From: Joseph Maphosa [REDACTED]
Sent: 08 April 2021 17:48
To: Simon Davis <Simon.Davis@arun.gov.uk>
Cc: Daniel Vick <Daniel.Vick@arun.gov.uk>; [REDACTED]
Subject: RE: North of Summer Lane, Pagham P/70/19/RES & P/29/21/DOC

Subject: North of Summer Lane, Pagham P/70/19/RES & P/29/21/DOC

PROJECT SUMMER LANE, PAGHAM				CLIENT HANBURY PROPERTIES LTD	
DRAWING TITLE SECTION 278 HIGHWAY WORKS				vectos. 4th Floor Oxford Place, 61 Oxford Street, Manchester, M1 6EQ	
DRAWN AM	CHECKED PW	DATE 16.02.2021	SCALE AT A1 1:200	DRAWING NUMBER VD16396-ID-SK-0005	REVISION A

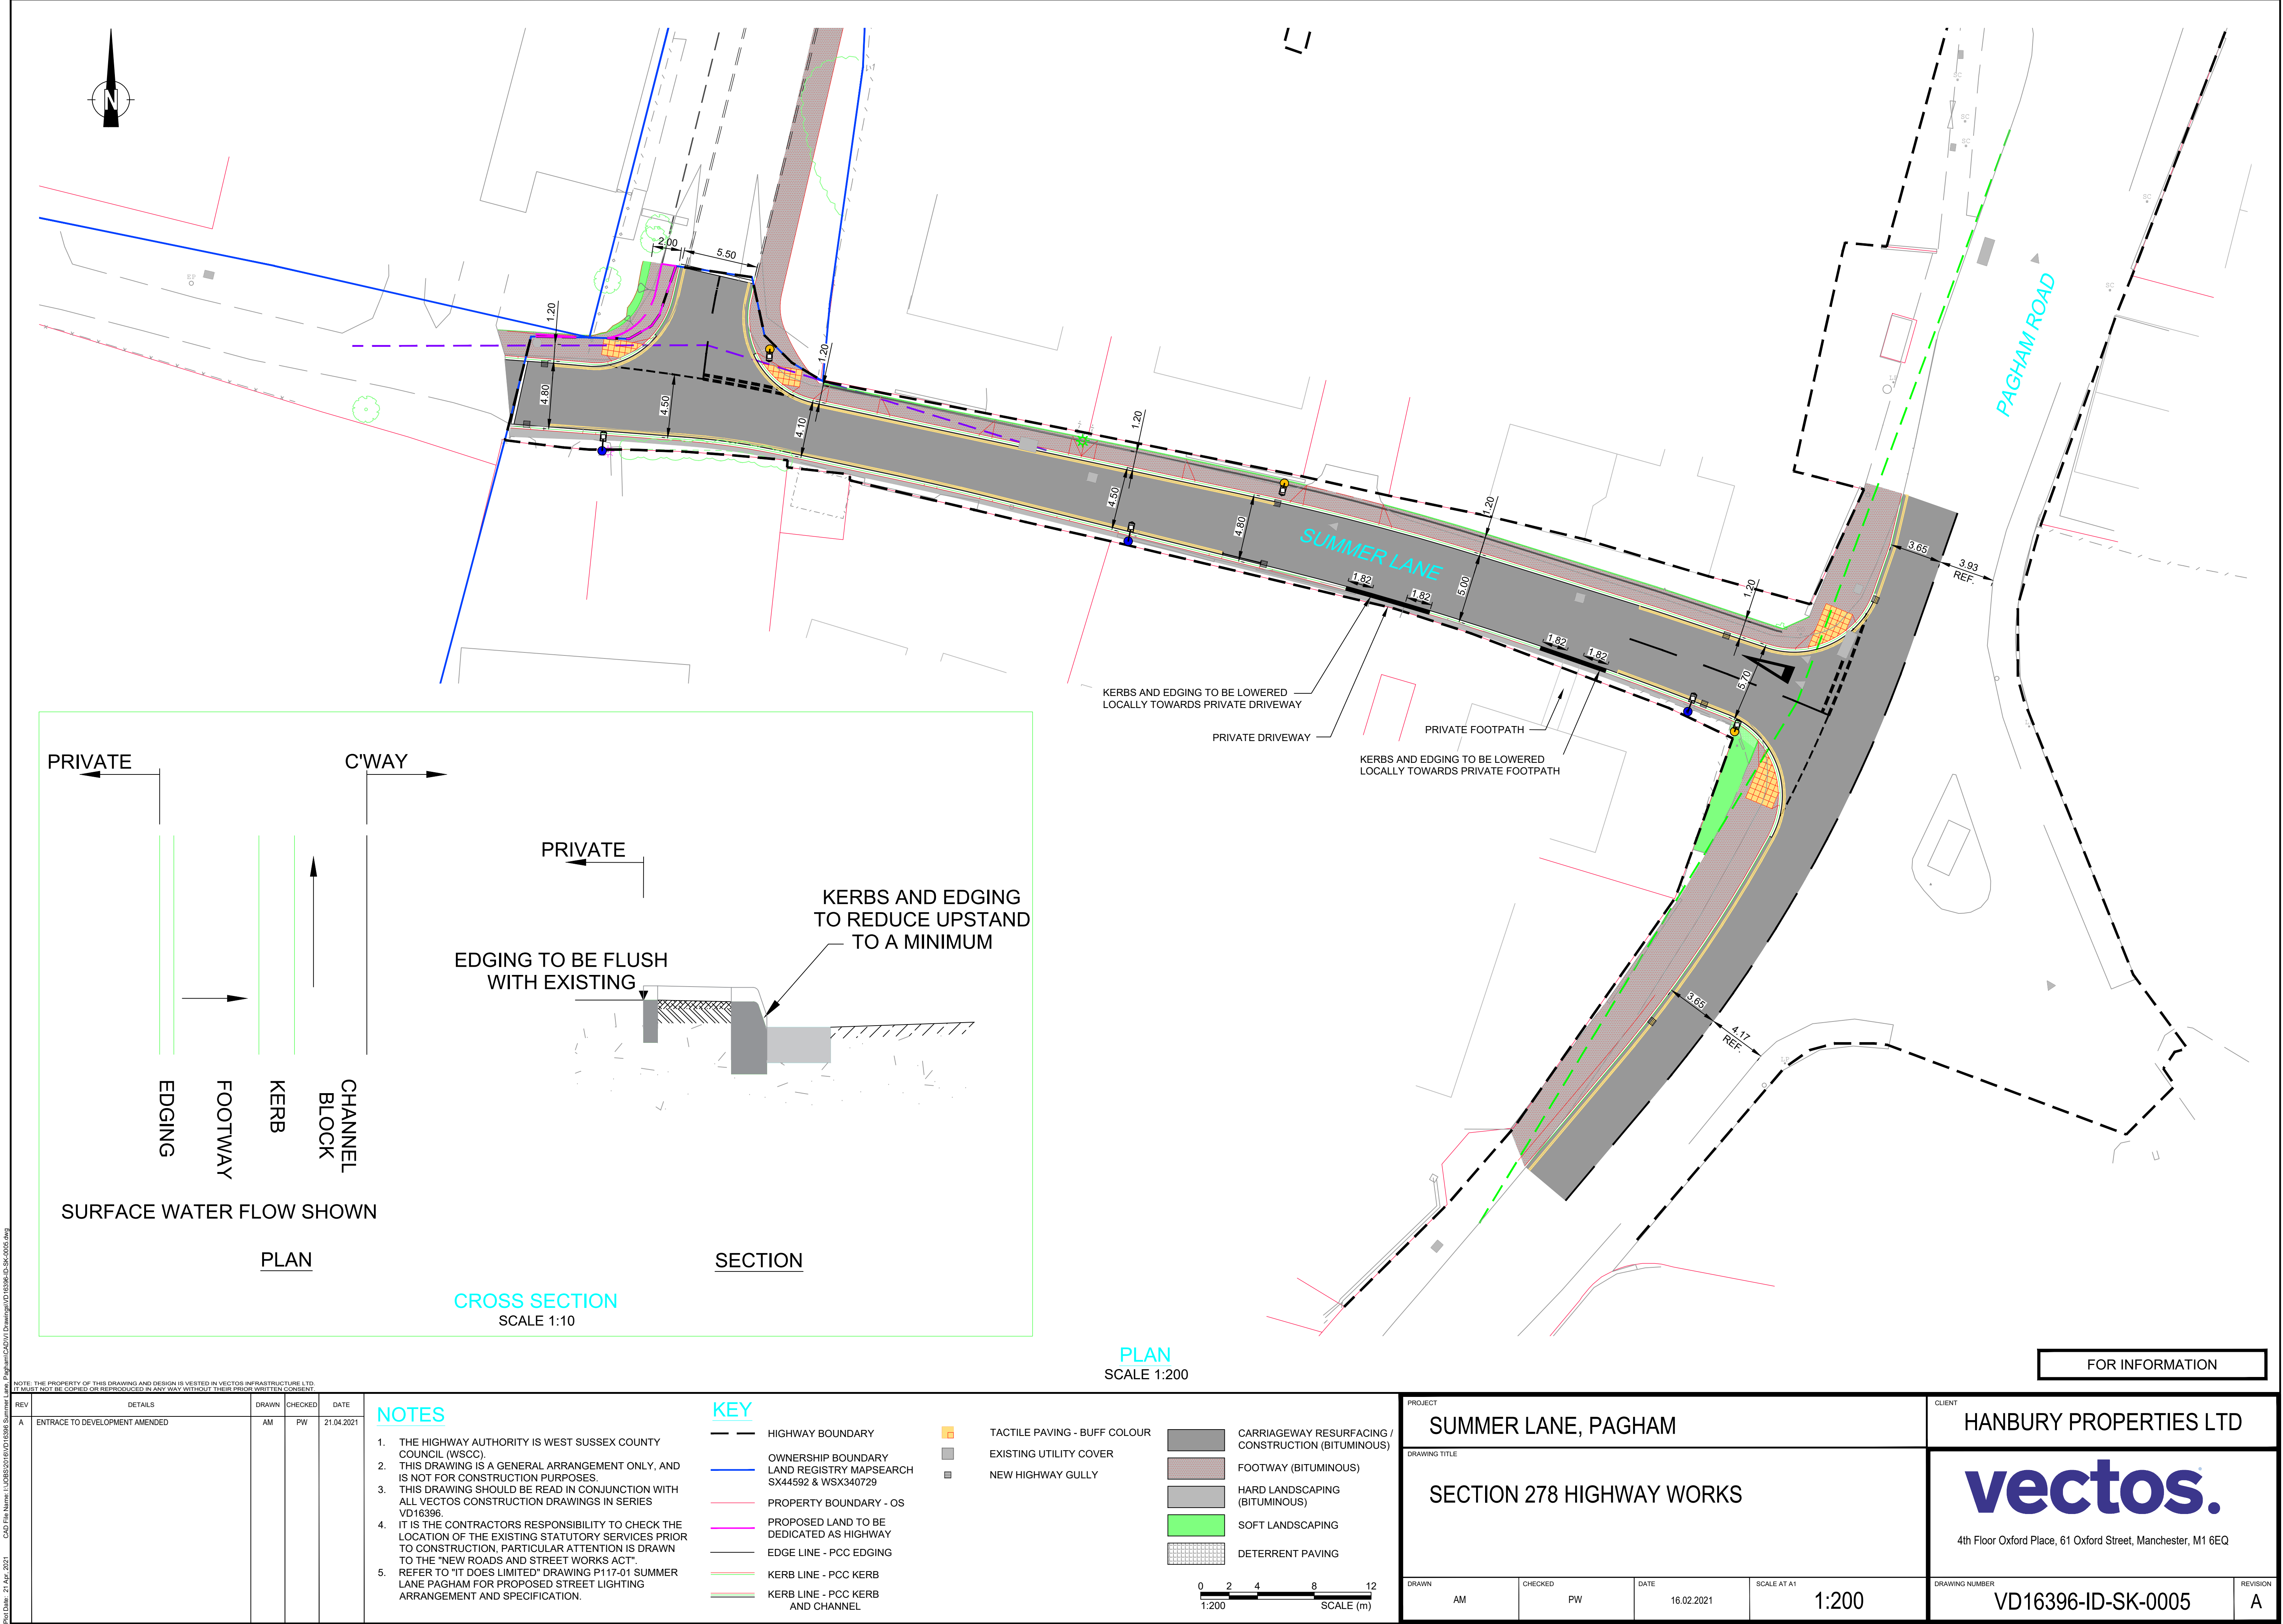
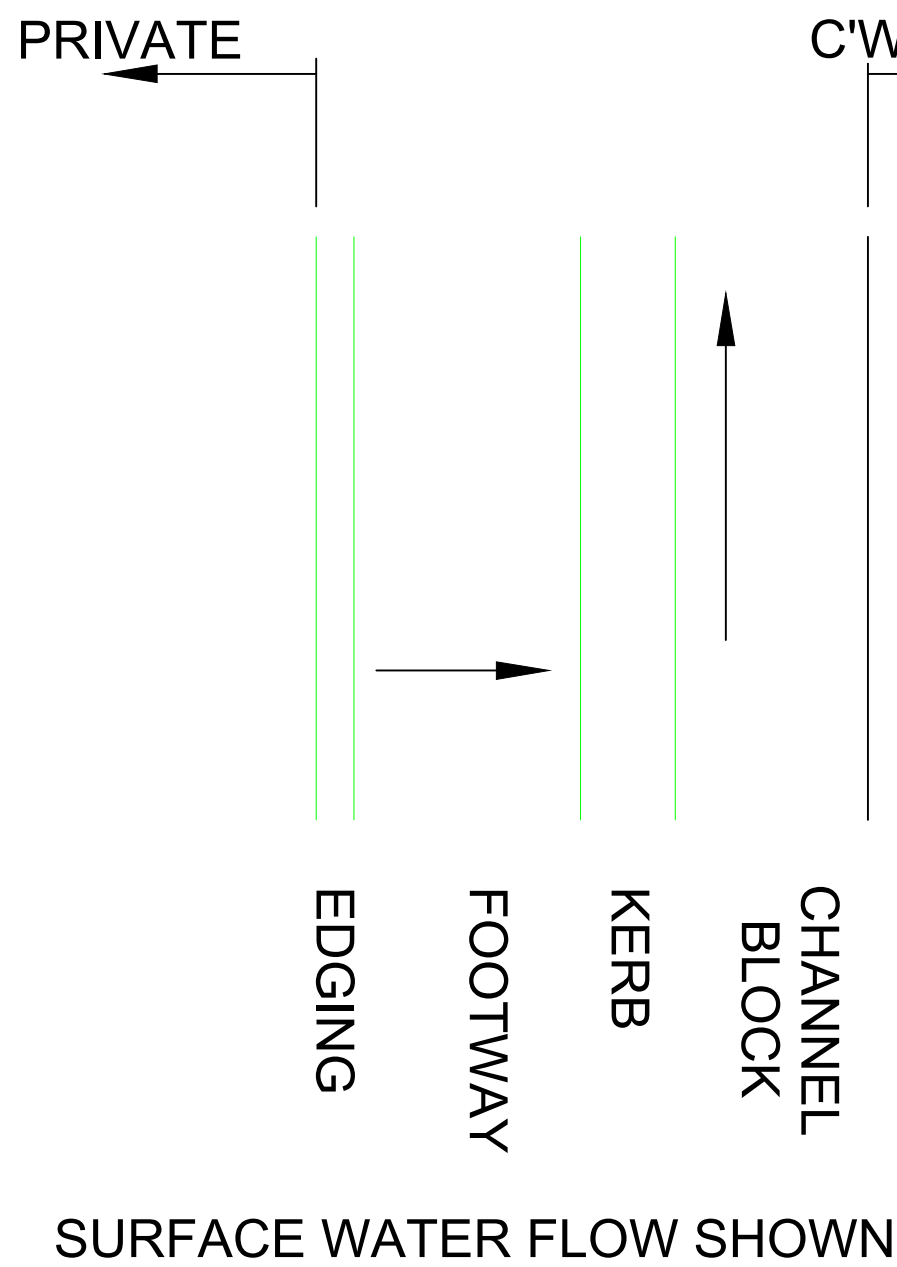
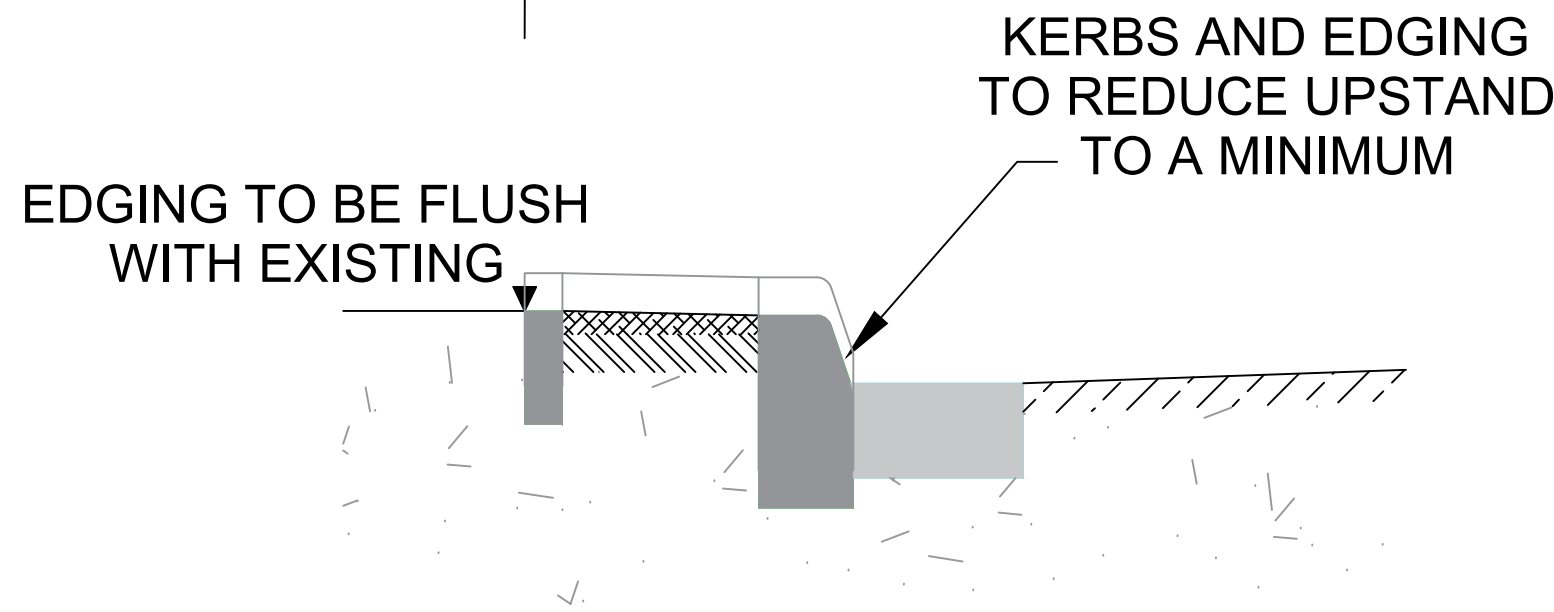
I also note your points regarding the access. However, you did not respond to my point *"The only obvious issue I can see from comparing the plans is that the s.278 drawing no longer shows any pavement on the eastern side but then I haven't seen the access on site."*

What I meant was that the approved plans show pavement on both sides of the access road extending north into the development site from the junction with Summer Lane. The S.278 drawing only shows such pavement on the west side of the access road.

Separately, I am aware of recent concerns expressed in relation to P/29/21/DOC which you can see on our website. It has been stated that the access being constructed on the ground (assumed to be the access to the eastern parcel) is not in accordance with the access plan approved under P/58/15 OUT, the access plan approved under P/70/19 RES or that shown on the drawing submitted under P/29/21/DOC. The only obvious issue I can see from comparing the plans is that the s.278 drawing no longer shows any pavement

on the eastern side but then I haven't seen the access on site. Please can you look into this and comment please.

I have double checked with site team who have provided the photo attached showing works currently underway to construct a footpath within the site boundary to the east of the site access in accordance with the plans approved under the Reserved Matters application. Also attached is the construction drawing (**1177_WD_111 Rev F**) which the site team are working to which clearly shows an internal site footpath linking up to the public highway footway.

The s278 drawing is accurate insofar as the works within the highway boundary however, for completeness I will submit an updated s278 drawing showing the footpath to the east of the site access.
